**RE: 86-96 MOUNT STREET & 100 MOUNT STREET, NORTH SYDNEY  
SECTION 75W MODIFICATION FOR COMMERCIAL AND RETAIL  
DEVELOPMENT (MP08\_0241 MOD 1) – PART 3A CONSENT**

**REPORT TO THE GENERAL MANAGER**

**ADDRESS/WARD:** 86-96 Mount Street & 100 Mount Street, North Sydney (V)

**PLANS REF:** Drawings numbered DA107 to DA140, dated 12 August 2011, drawn by Skidmore, Owings Merrill LLP and Architectus.

scale 1:400 @ A3, 1:200 @ A1 drawing no.  
drawn **DA141**  
checked MC issue  
project no 110059 **B**

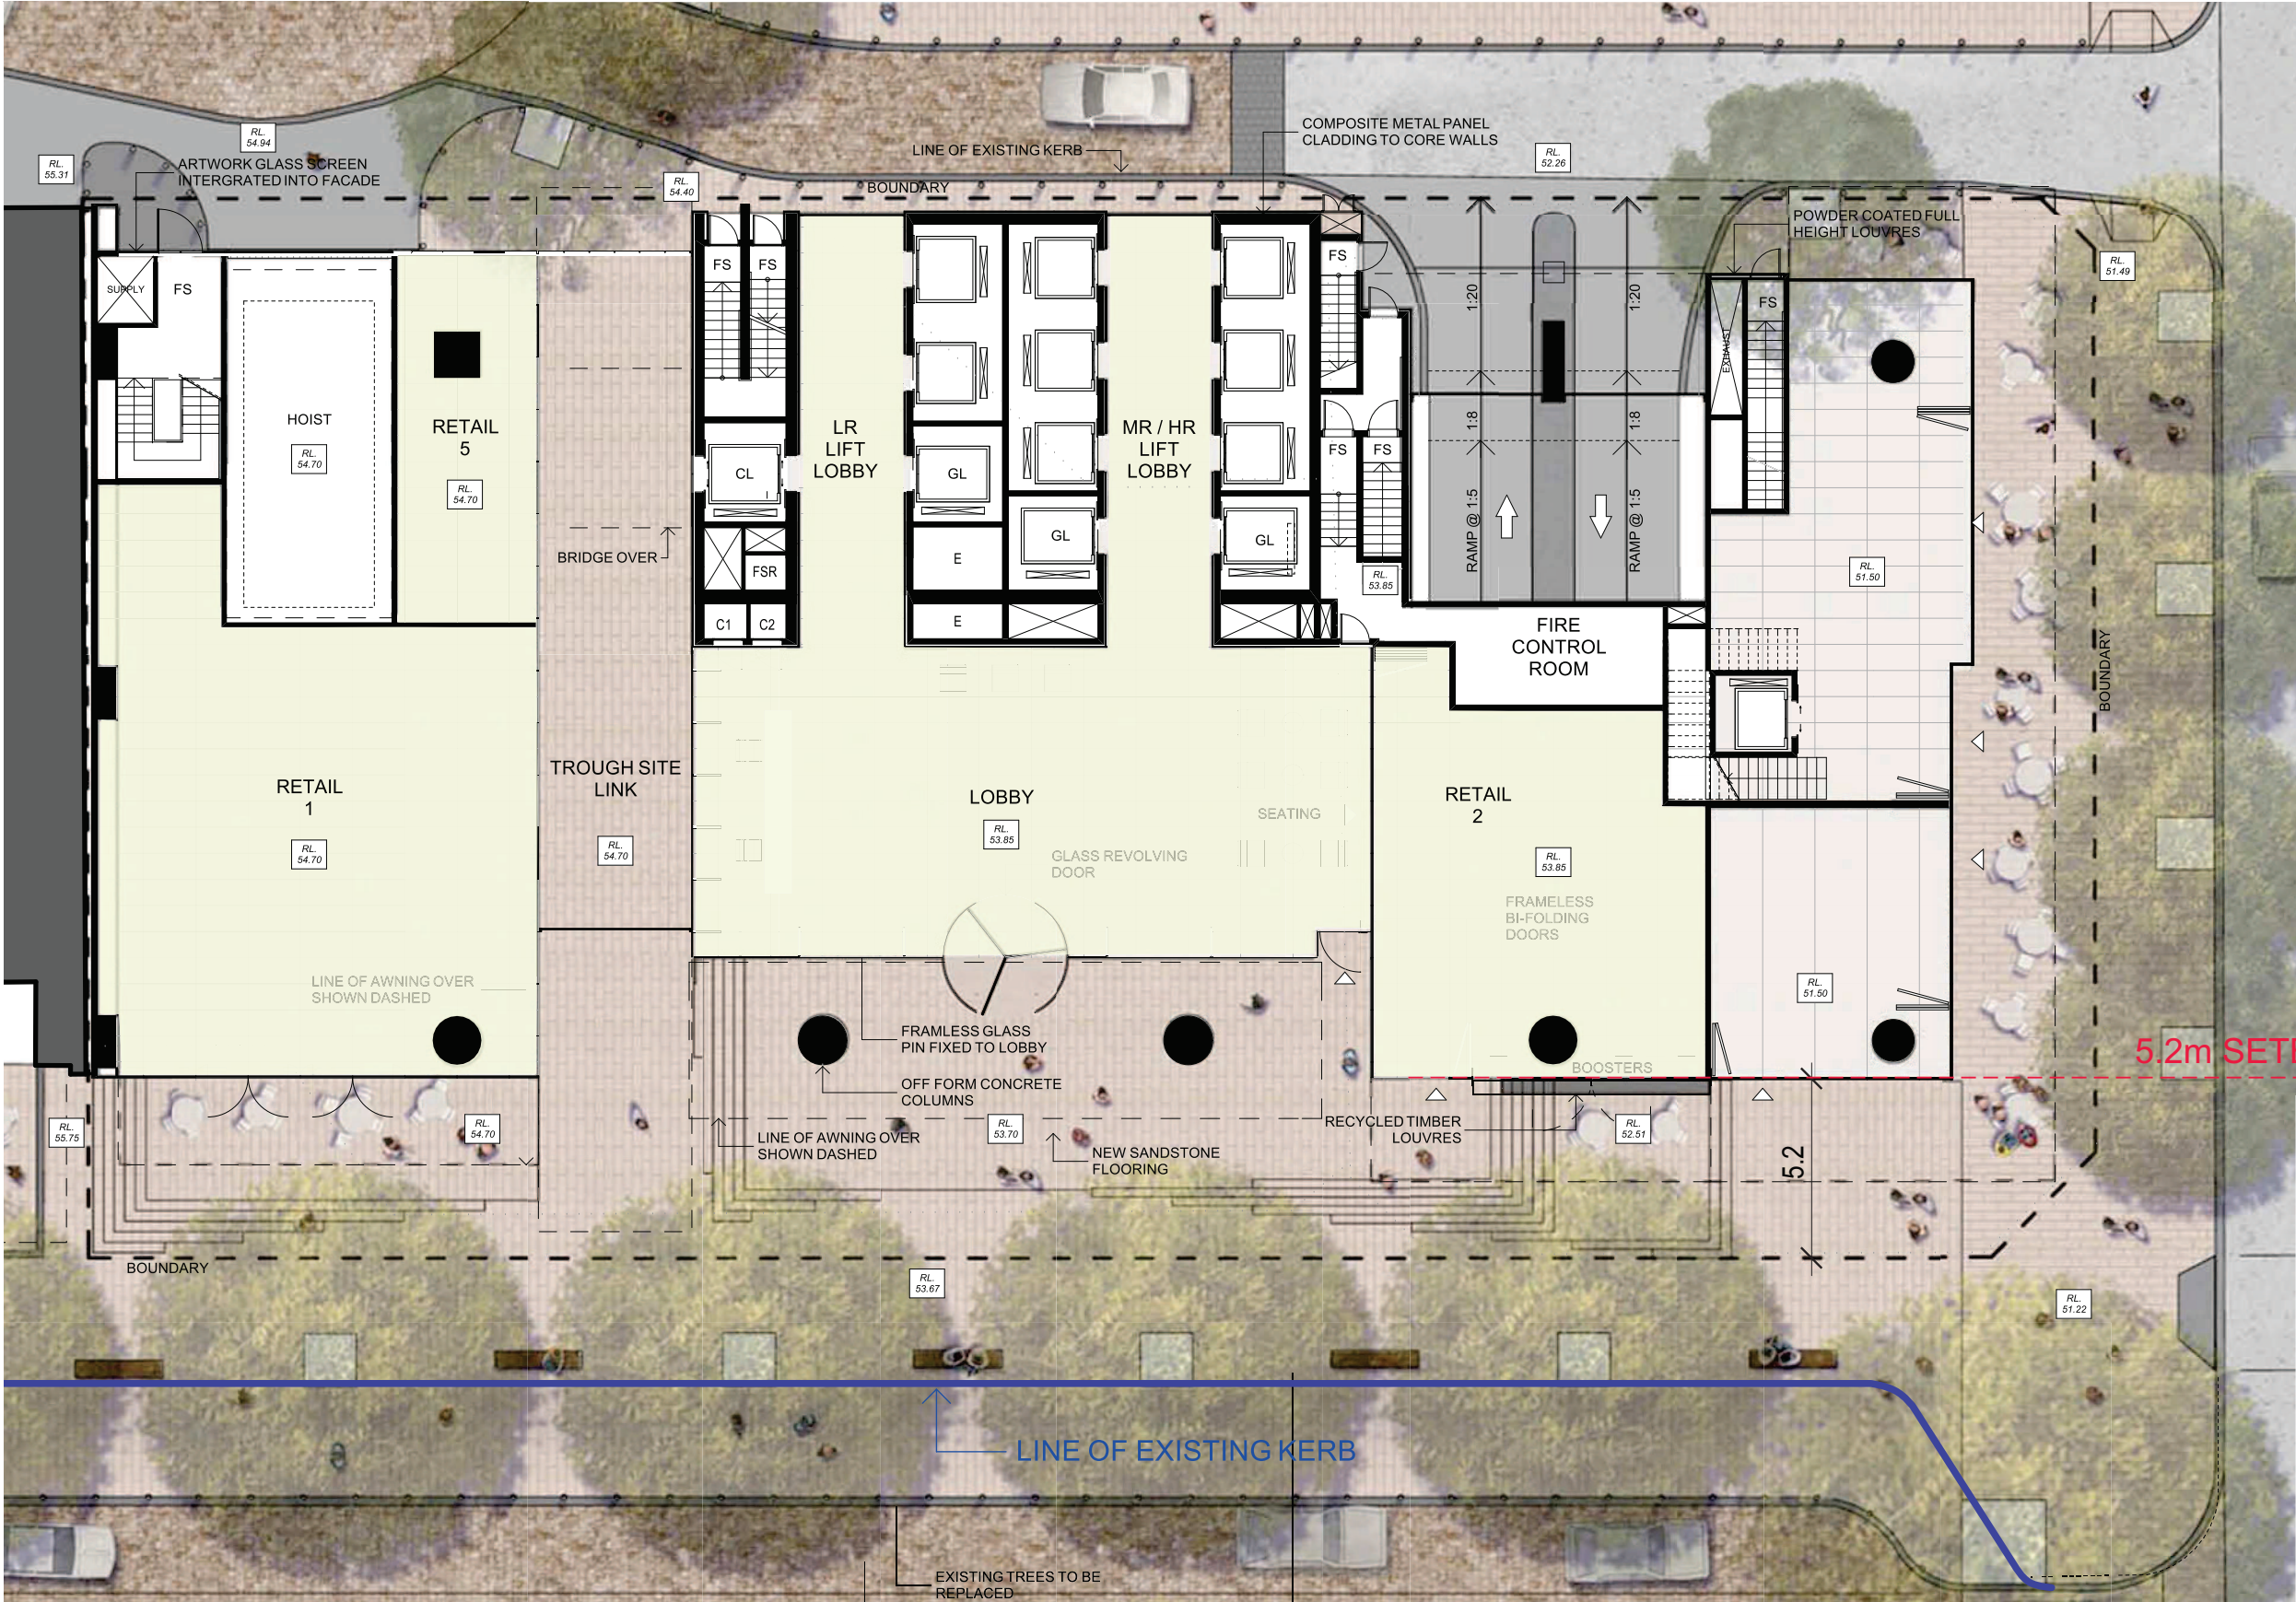
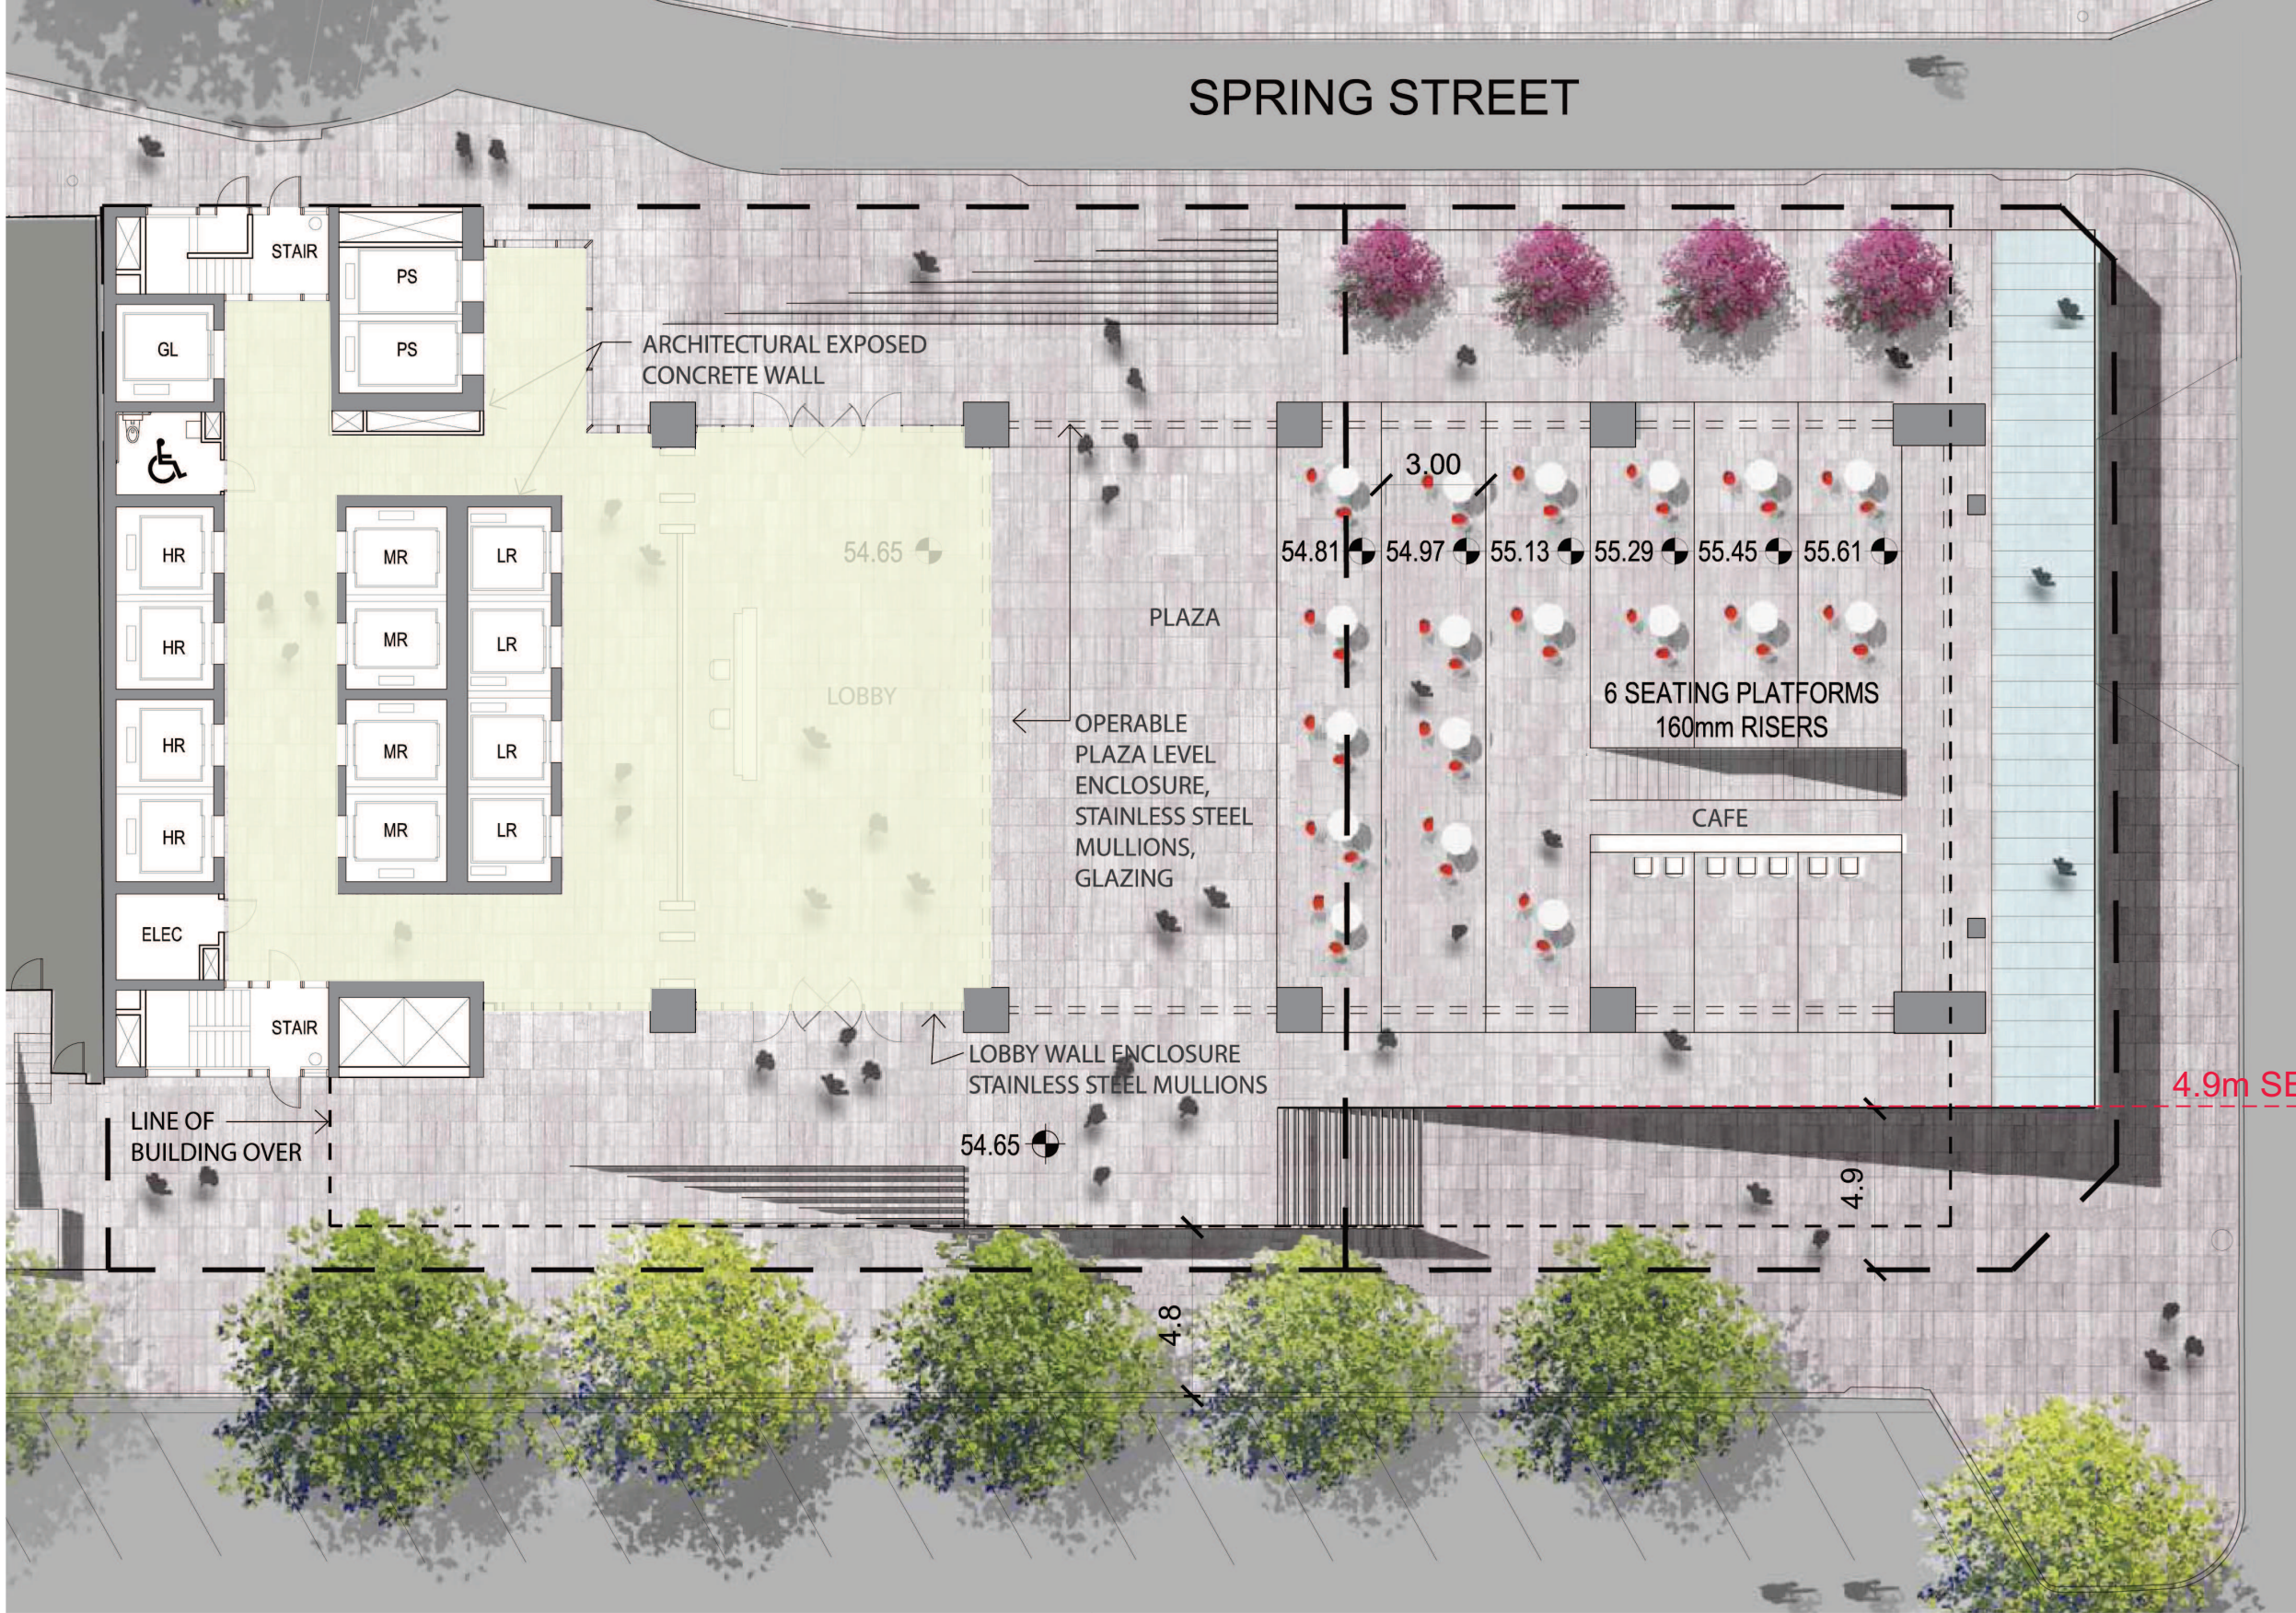
- H. **THAT** the setback on the Mount Street elevation be increased from 4.2m to 4.8m.

*The 3.6m setback from Mount Street is considered inadequate and an additional 1.2m, which would provide a 4.8m total setback is required in order to facilitate improved pedestrian movement on Mount Street.*
